PROPOSED CONNAH'S QUAY LOW CARBON POWER

PROJECT PLANNING INSPECTORATE REFERENCE: EN010166

RE: NATURAL RESOURCES WALES' WRITTEN SUBMISSION FOR DEADLINE 4

ANNEX A – NRW COMMENTS ON THE CHANGE APPLICATION

Environmental Statement Volume III
Figure 12-2: Designated Sites with Marine Ecology Features

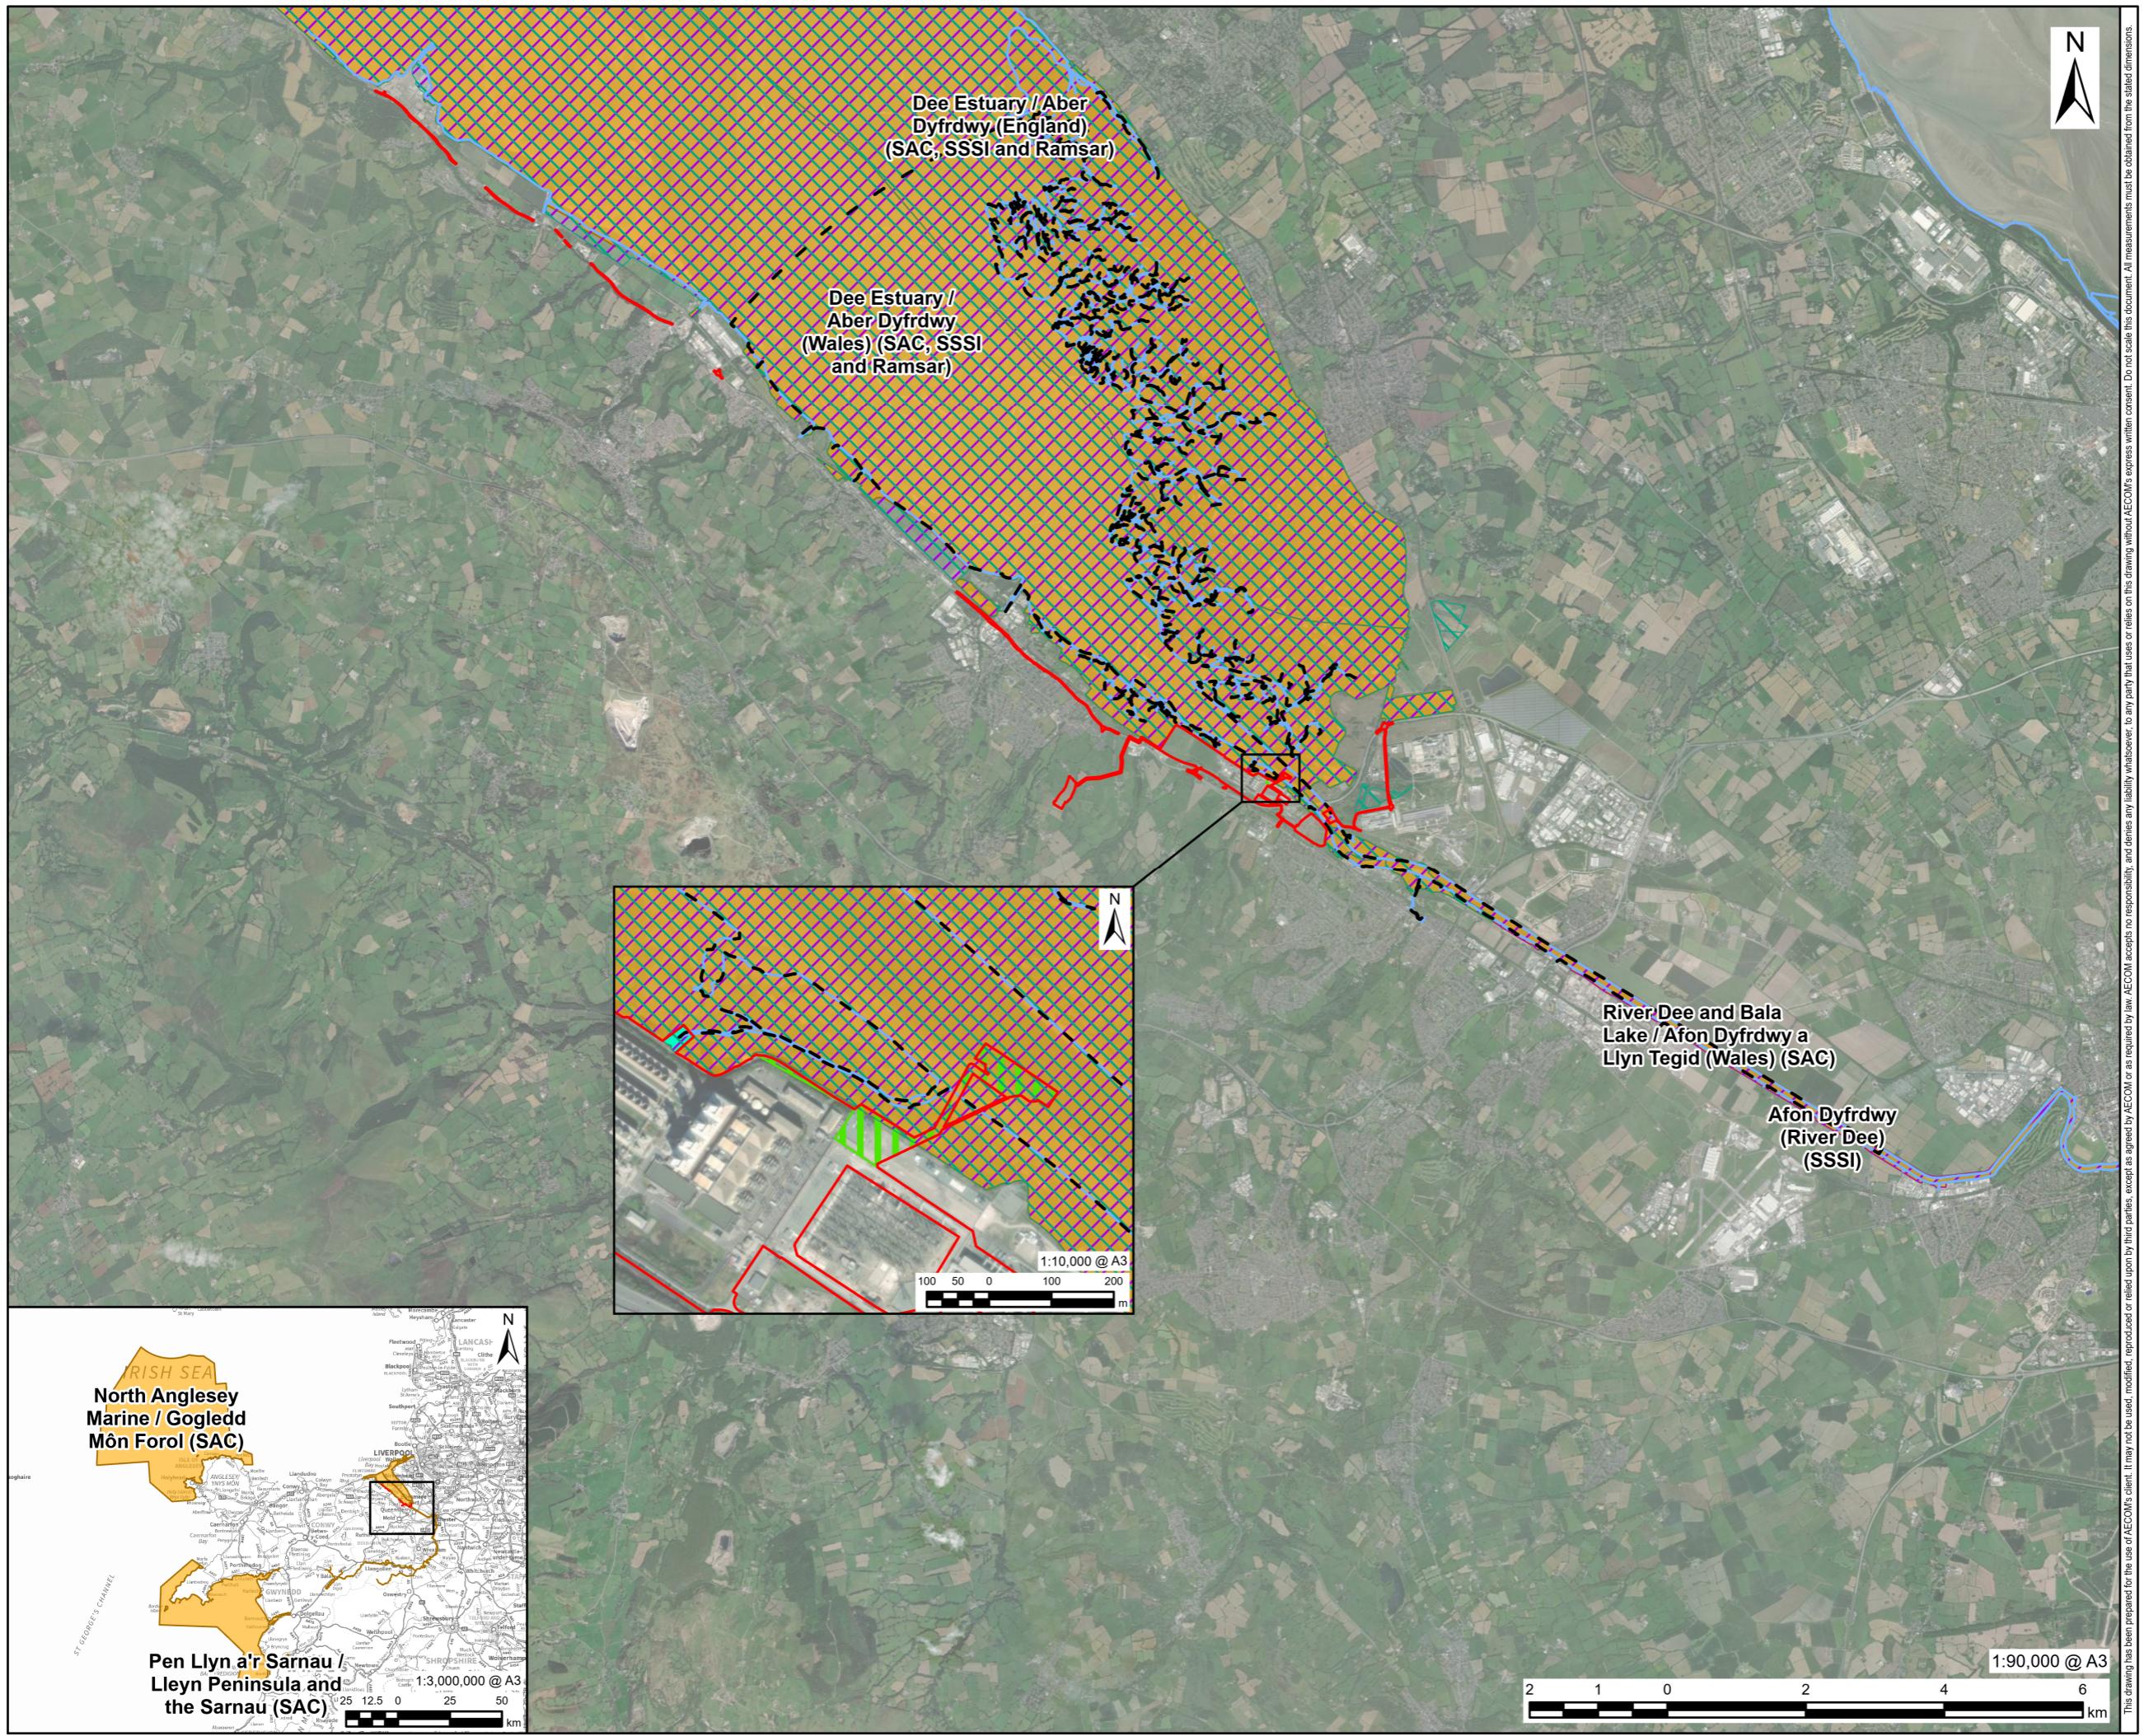
- 2.5 At the Dee Estuary SAC, the Applicant's predicted in-combination nitrogen deposition process contribution reduced from 2.4% of the critical load to 2.3%, and the individual contribution from Connah's Quay power station proposal alone reduced from 1.4% to 1.3% of the critical load. The Applicant has made no changes to the predicted saltmarsh area affected either in-combination (445 ha) or alone (245 ha).
- 2.6 We therefore maintain our key concerns about nitrogen deposition on the Dee Estuary SAC Annex I saltmarsh habitat (please refer to our Written Representation [REP1-0173] and current draft SoCG [REP3-029/030] for further details regarding this).

Environmental Statement Volume III Figure 15-8: Zone of Theoretical Visibility - 145 m CCP Absorber Column (including Stack) Height plus 7.4 m Raised Ground Level

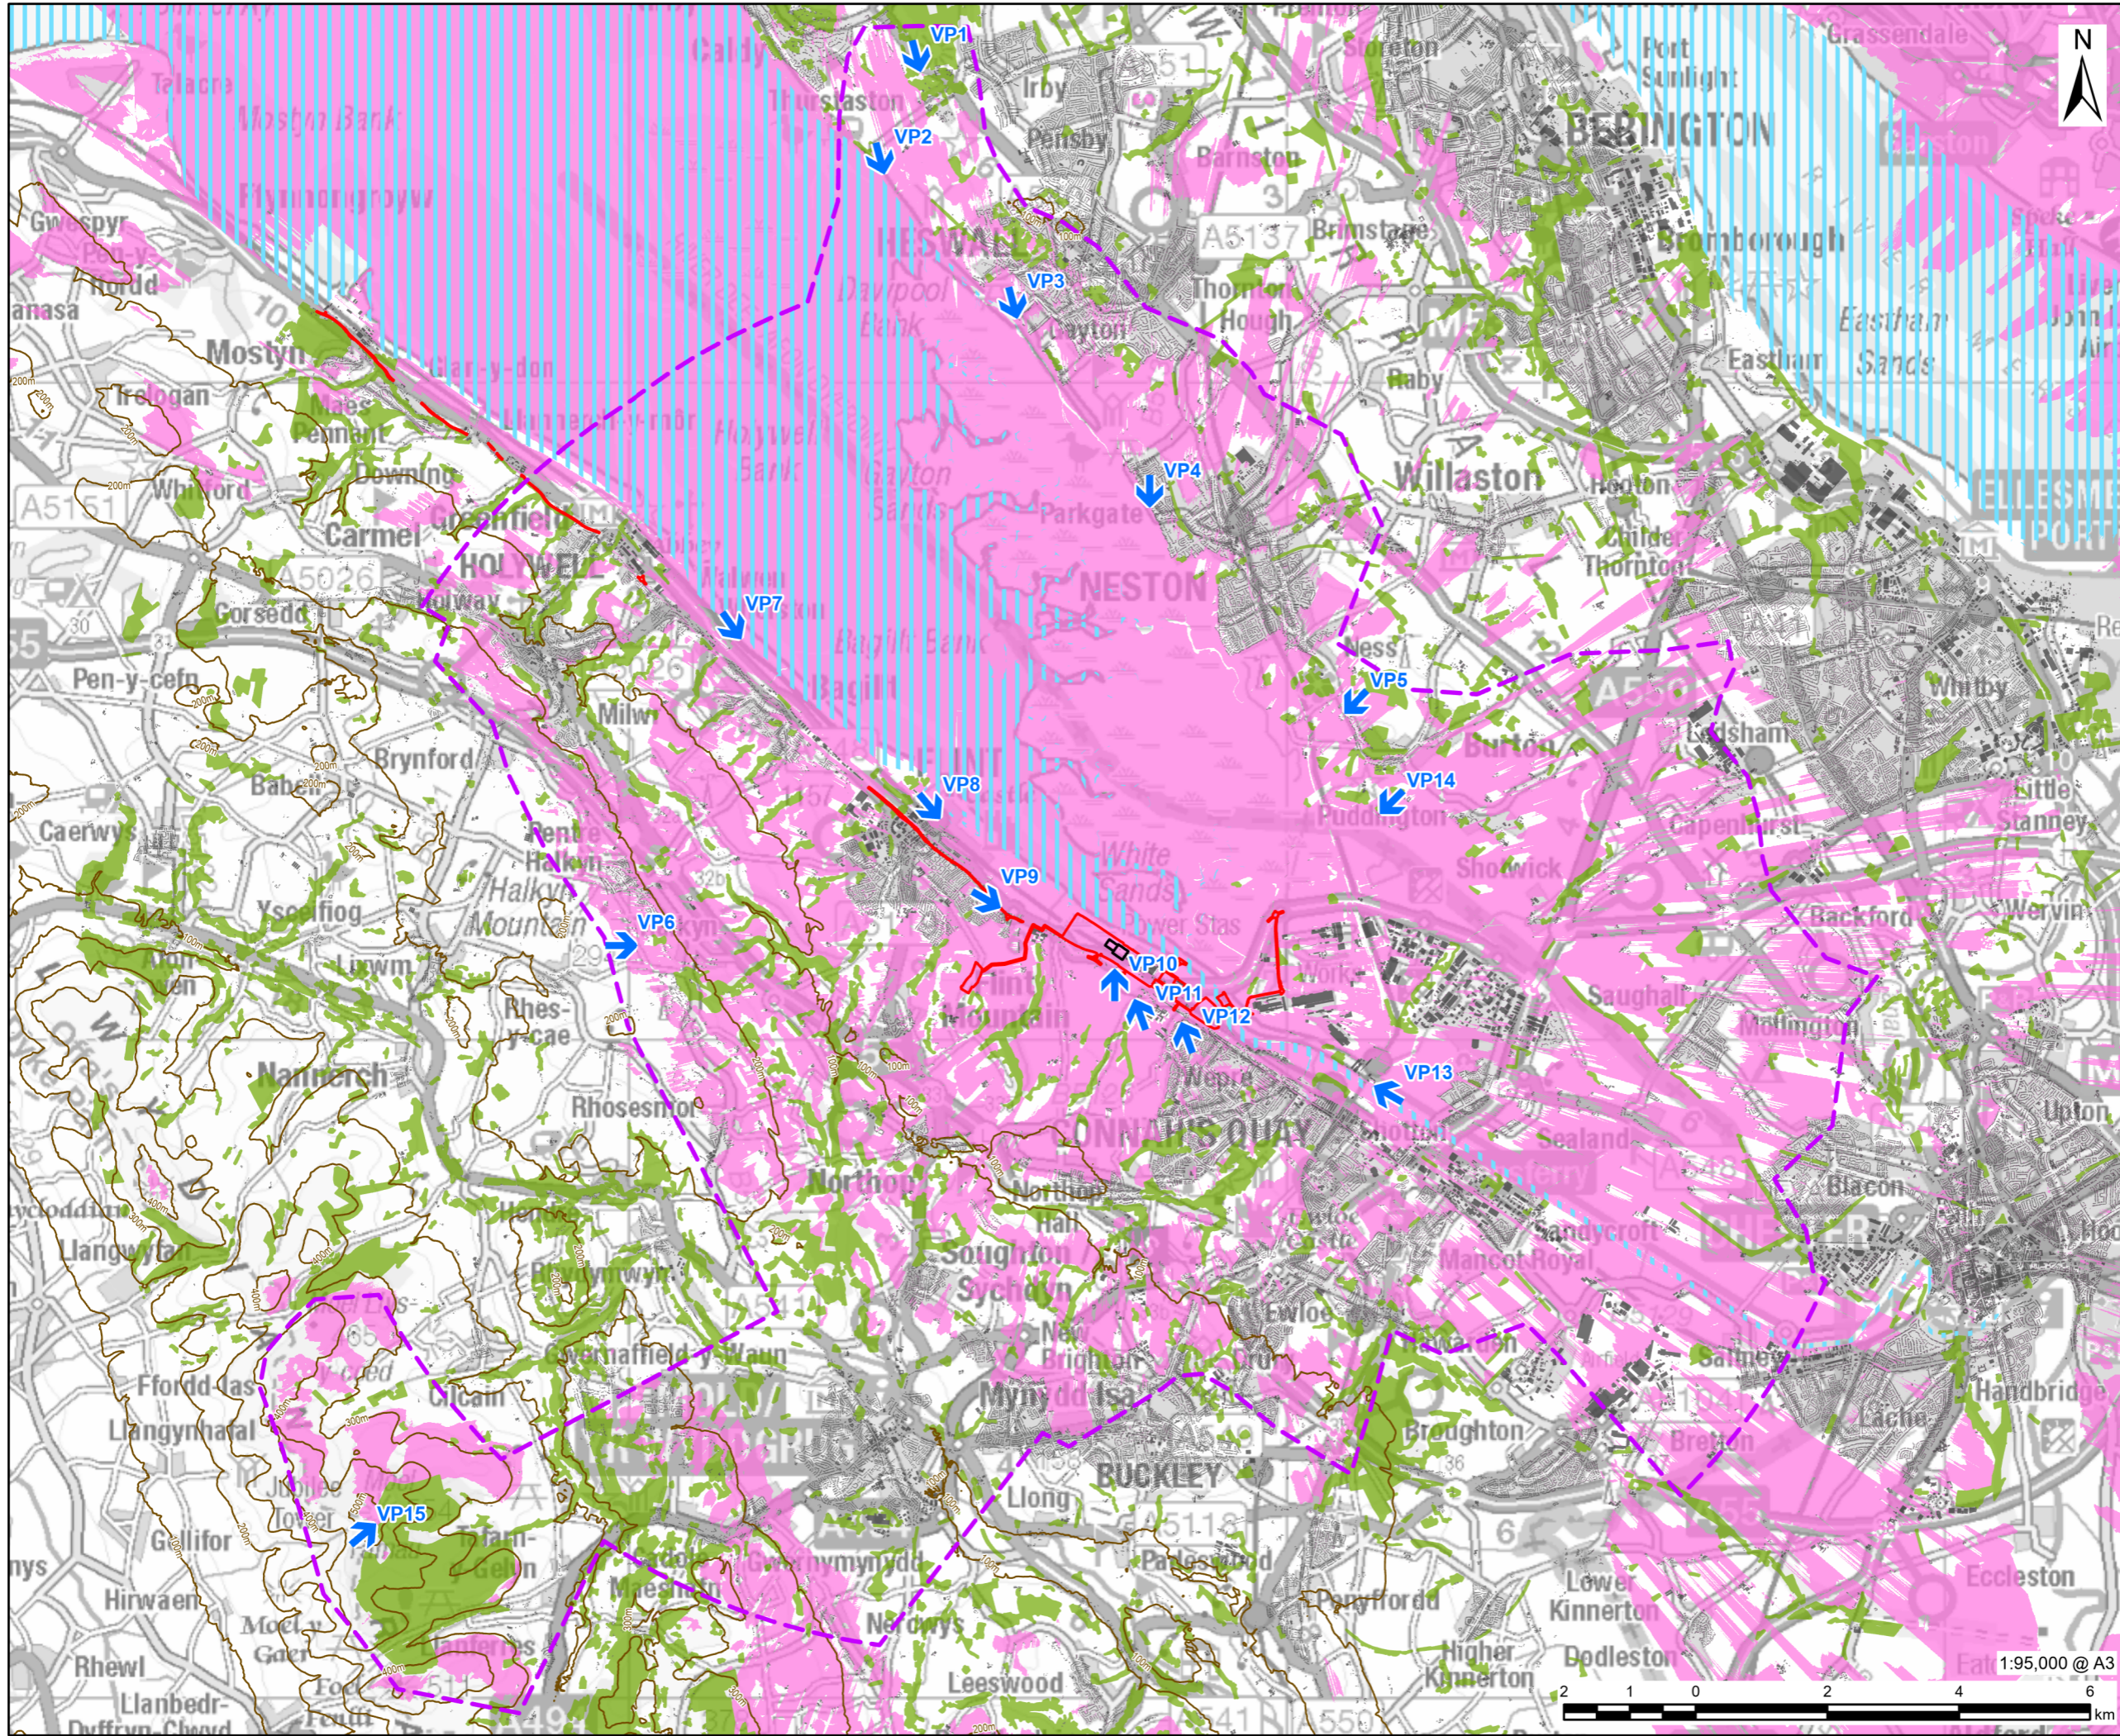
5.1 We note that Proposed Change 4 would result in a reduction in the heights of the following structures:

- HRSG Stacks (reduced from 150m to 130m)
- CCP Absorbers (reduced from 150m to 92m)
- CCP Absorber Stacks (reduced from 150m to 145m)

- 5.2 We understand that the Applicant considers Proposed Change 4 is not anticipated to give rise to any new or different likely significant effects and therefore is not expected to materially alter the landscape and visual impact assessment conclusions in ES Chapter 15 [APP-053].

- 5.3 As far as it concerned the Clwydian Range and Dee Valley National Landscape (CRDVNL), our previous advice agreed with the conclusion of ES Chapter 15. We noted that, although there would be adverse visual effects within the CRDVNL, e.g. at Moel Famau, the effect on the visual amenity of people at this location would not be significant. We also agreed there would be no significant adverse effects on the special qualities of the CRDVNL. As Proposed Change 4 proposes to reduce the heights of the tallest elements within the proposed development, this conclusion would remain valid, and therefore we do not have concerns with the proposed change.
